Department of Primary Industries

OUT14/418

Discovery Point, Wolli Creek Stage 1 (MP10_0030) Proposed Modification

Comment by NSW Office of Water

ELECTRICAL & HYDRAULIC SERVICES
INFRASTRUCTURE
MASTER PLAN -
OPTION A

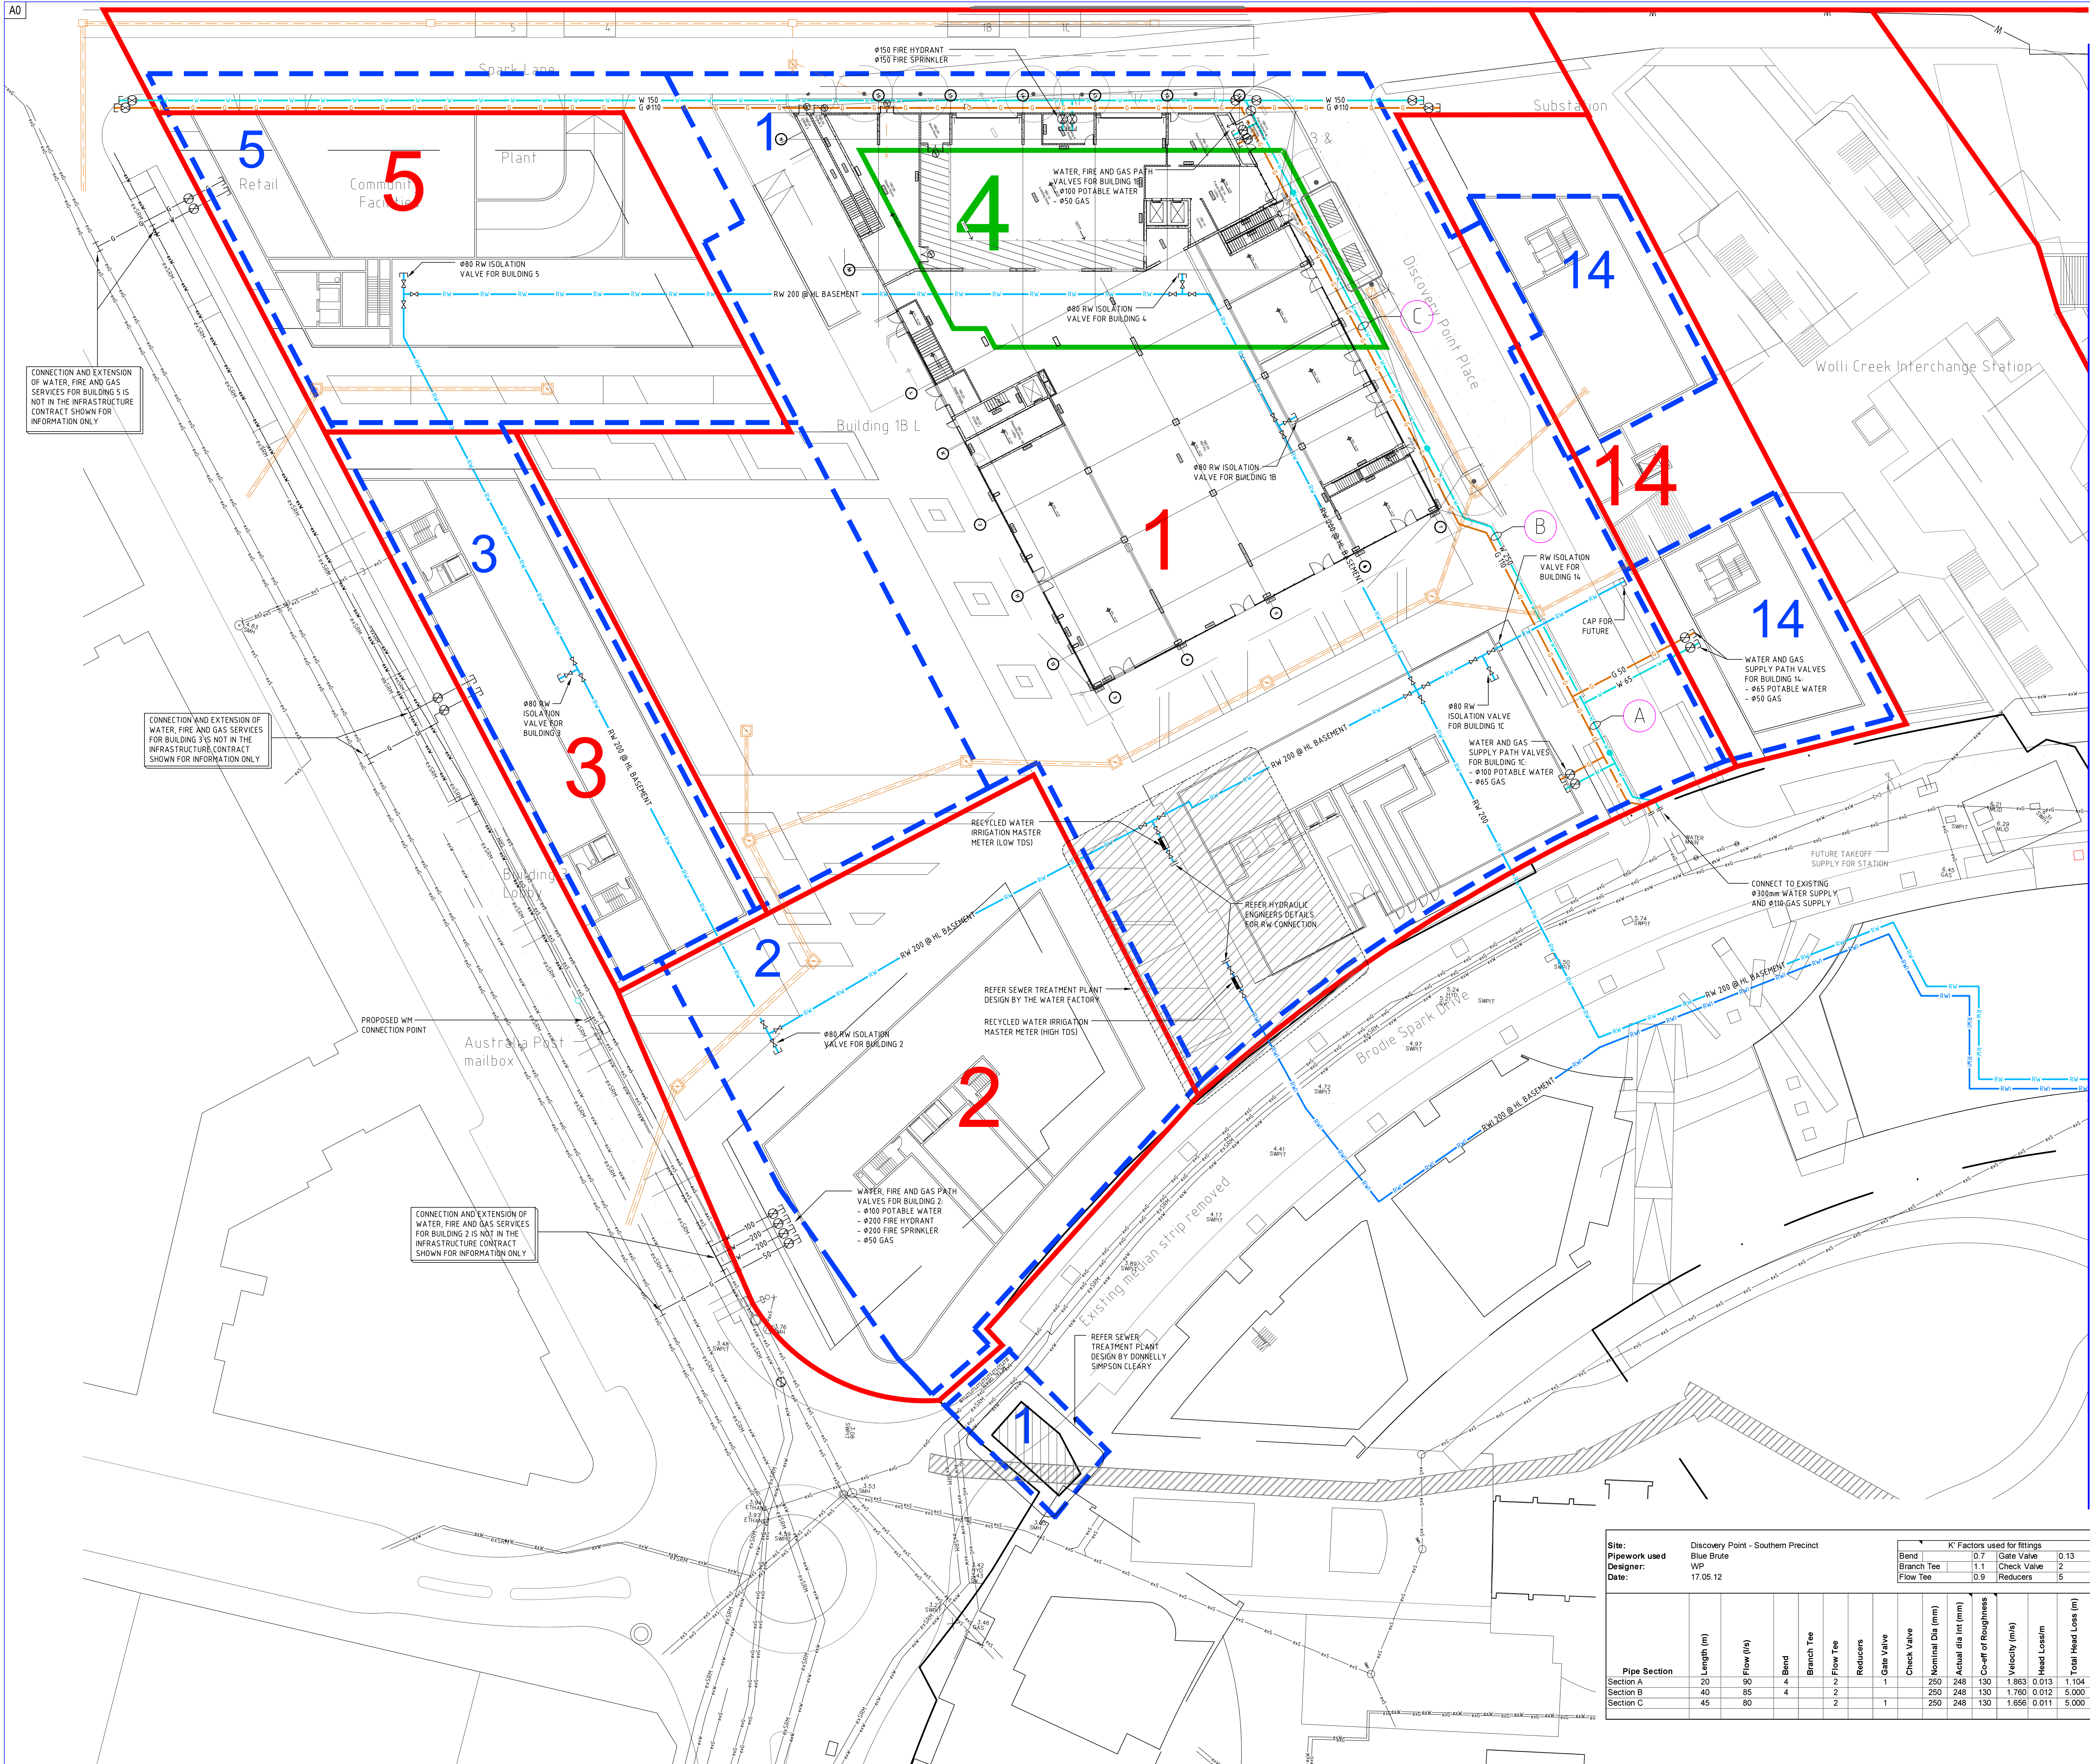
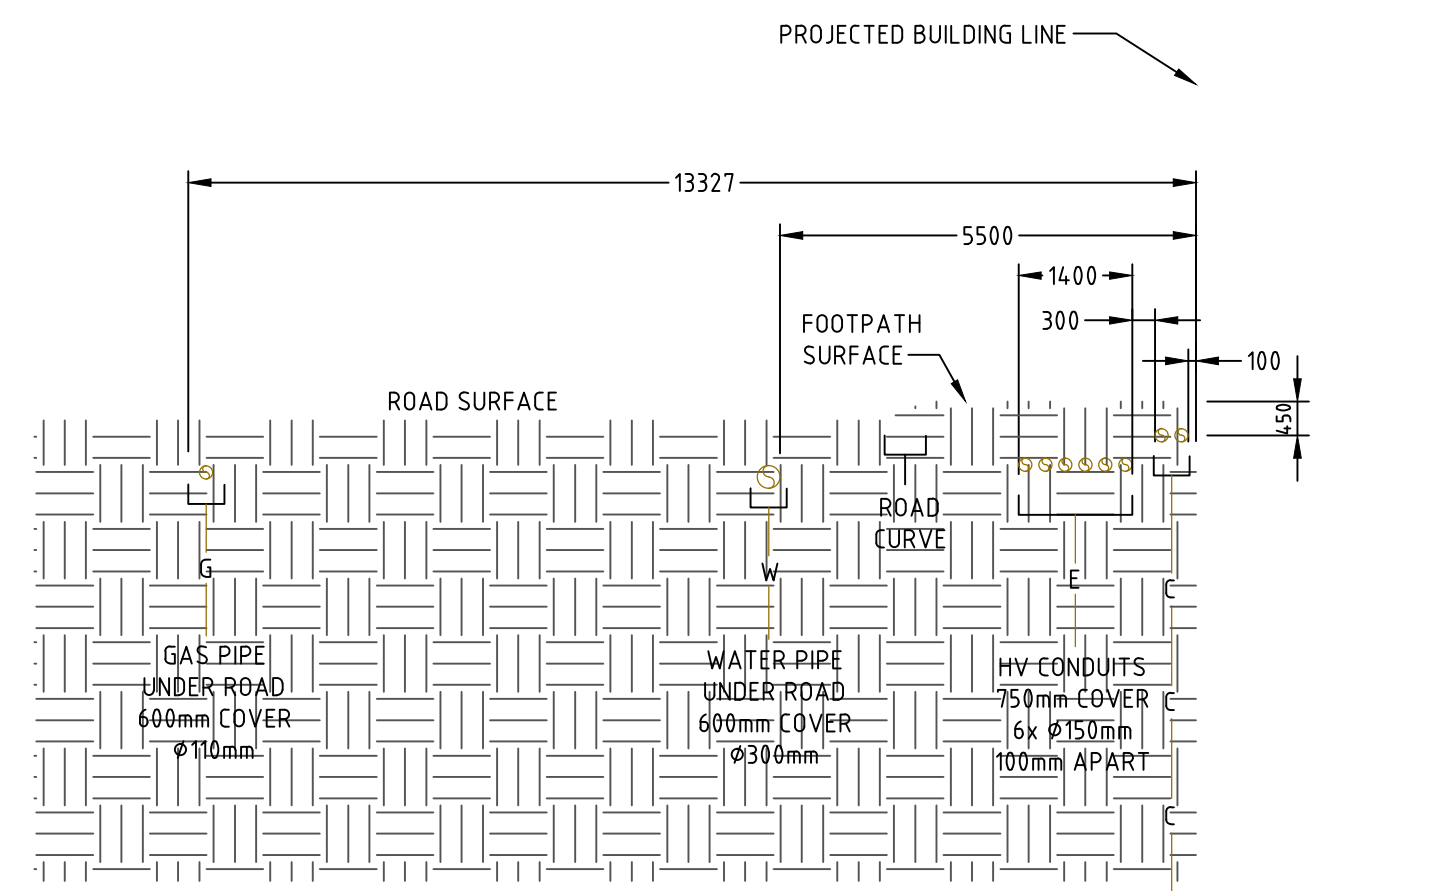
The current Modification application includes the installation of infrastructure works associated with reticulation from the on-site water recycling facility to future stages/building (page 5). The Modification Report outlines that the provision of this infrastructure does not raise any additional impacts not already considered in the original assessment (page 7).

The Office of Water requests clarification on the source of the water for the on-site water recycling and whether it will only consist of roof runoff or if it will include groundwater. If the recycled water is also from groundwater a licence may be required from the NSW Office of Water.
